November 22, 2023

SUBJECT: WDFW COMMENTS ON CU-23-00002 The Outpost

Thank you for the opportunity to comment on the CU-23-00002, The Outpost application, concerning the development of various recreation facilities including cabins, a lodge and associated facilities. Washington Department of Fish and Wildlife (WDFW) has reviewed the application and supporting documents. Our comments are regarding the project's impact on priority fish and wildlife habitats, particularly riparian habitats. Specifically, to ensure that if the application is approved that the development will not result in loss of Fish and Wildlife Habitat Conservation Areas (FWHCA) under Kittitas County Critical Areas Ordinance (CAO).

**CONCEPTUAL SITE PLAN
MULTIPLE PARCELS**

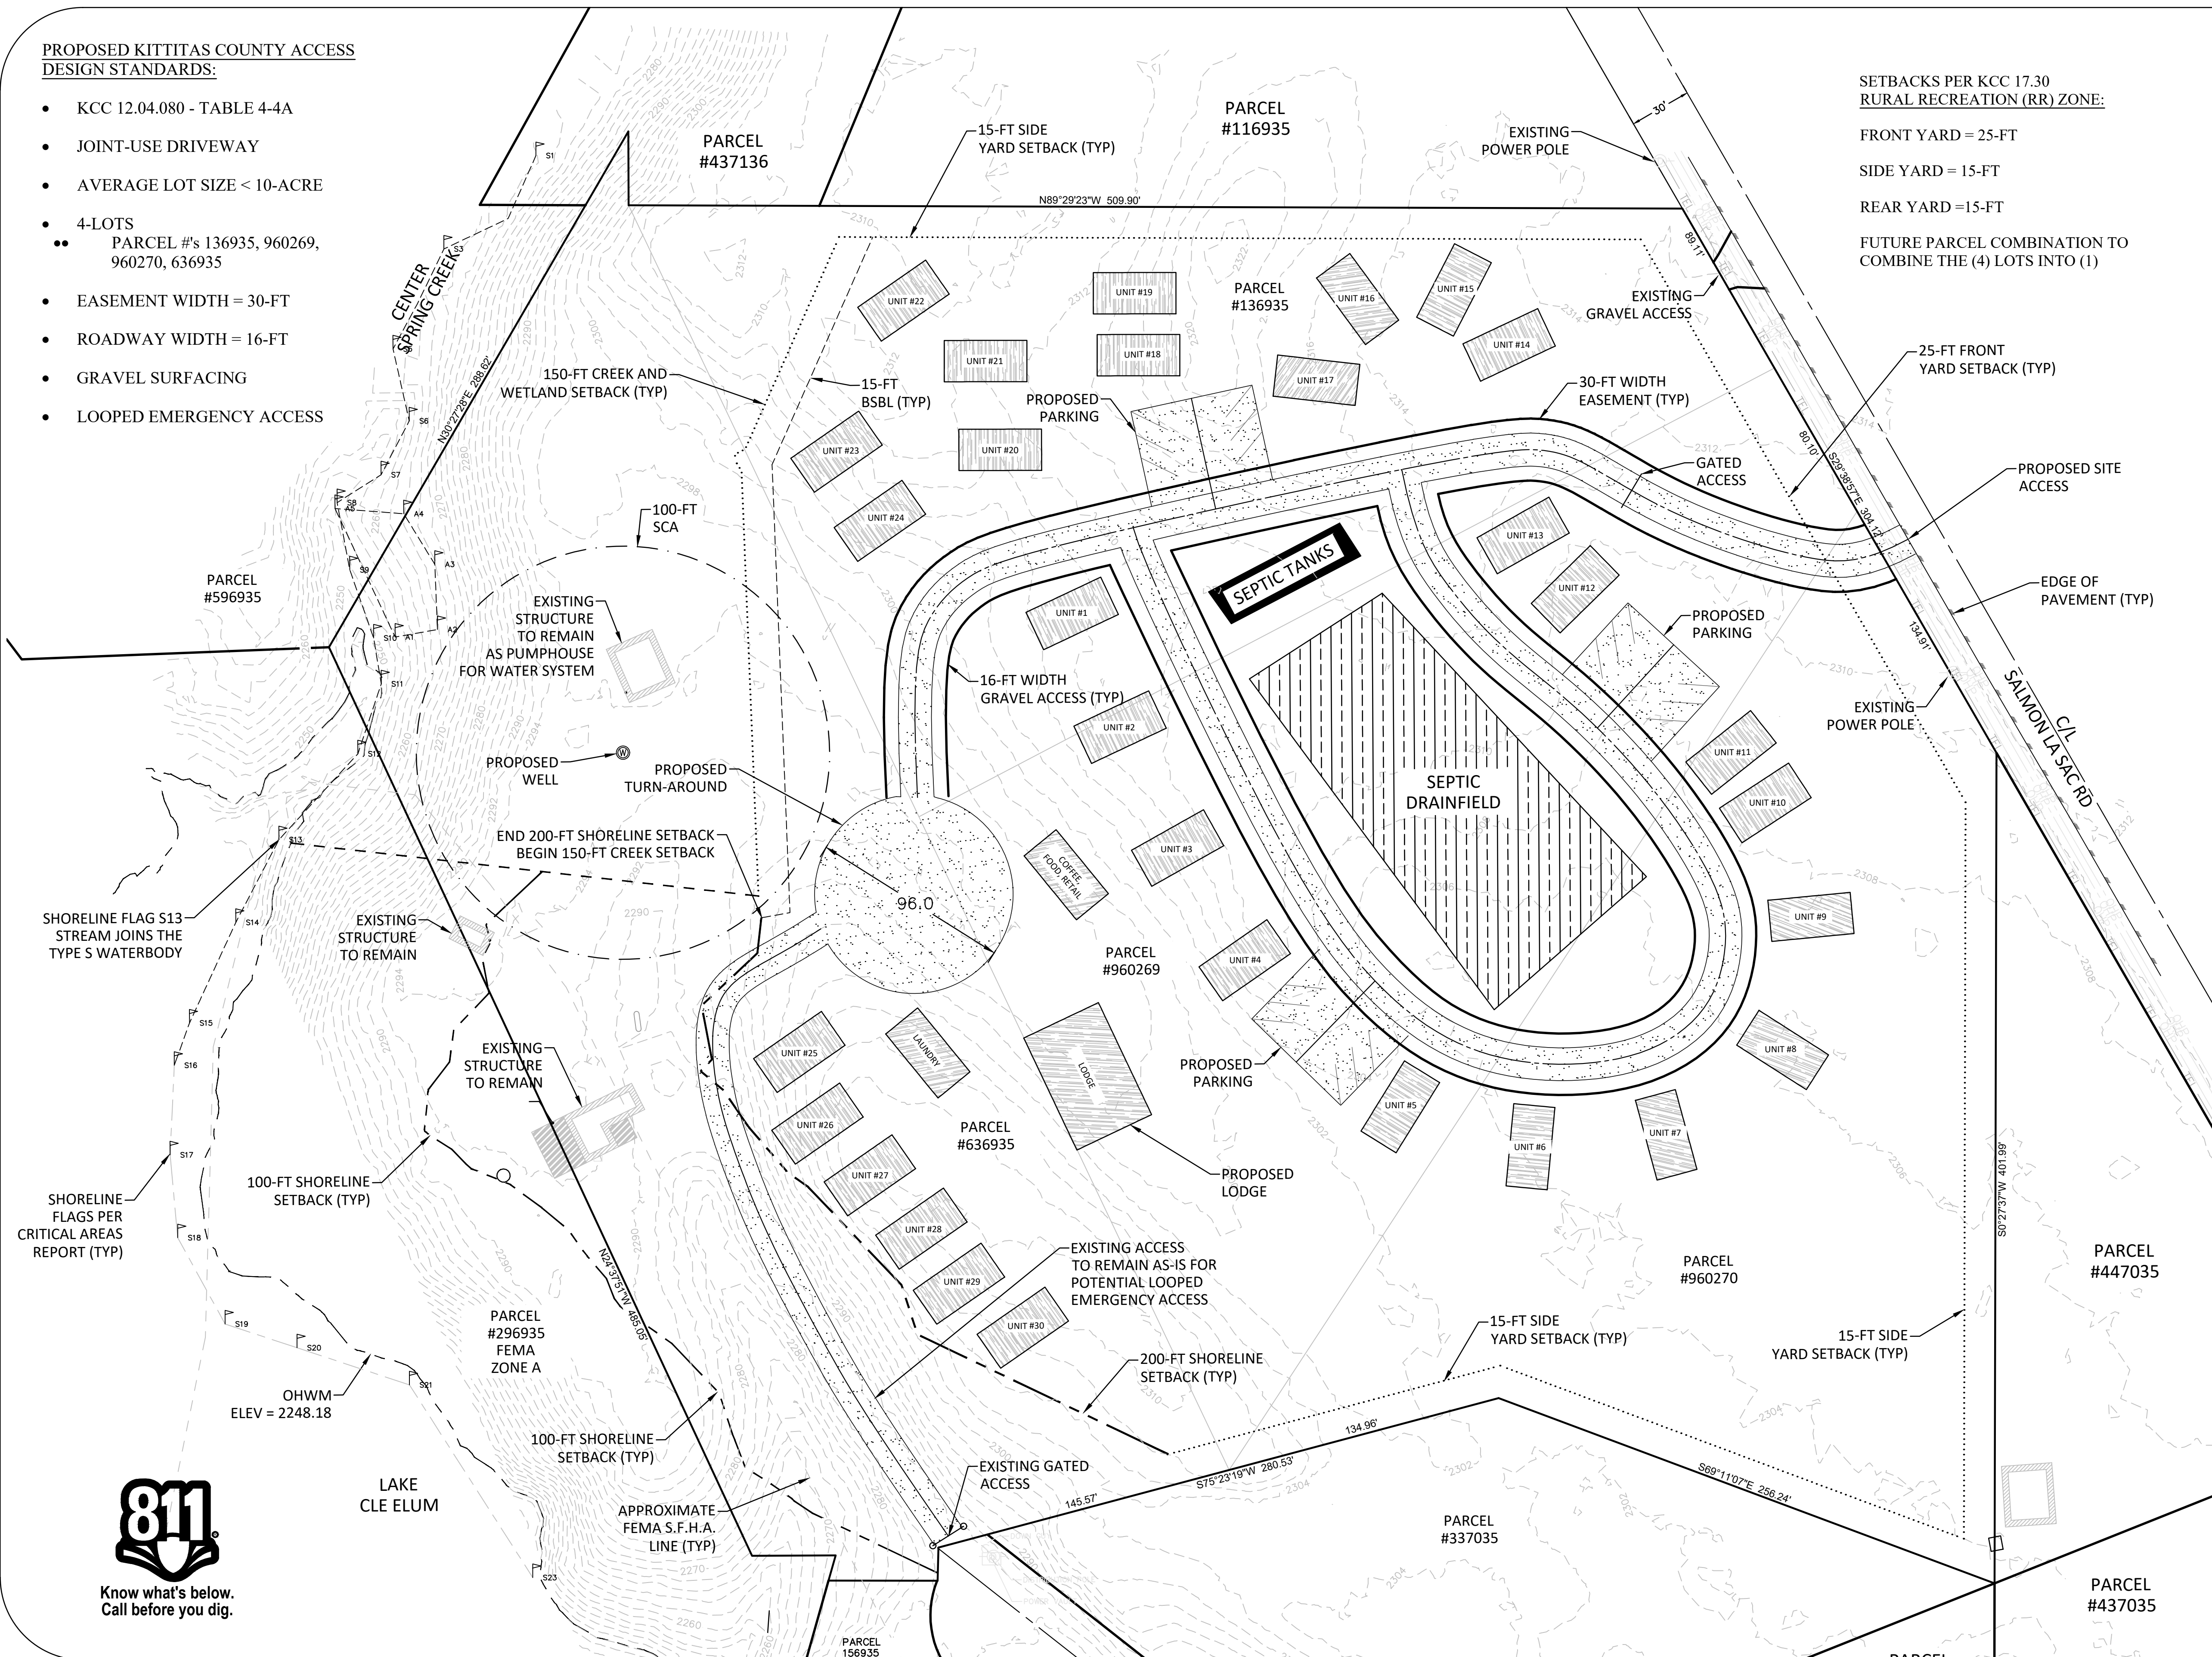
We appreciate that the updated site plan, dated October 16, 2023 correctly shows that the setback from Spring Creek is 150 foot and that all new facilities are located outside of this setback. If there are any further updates to the site plan, it is important that the setback from Spring Creek is maintained, including incorporation of any firewise setback as well. As Spring Creek is a fish-bearing stream, it is important to maintain the riparian area and that this proposal does not result in any loss of riparian area if approved.
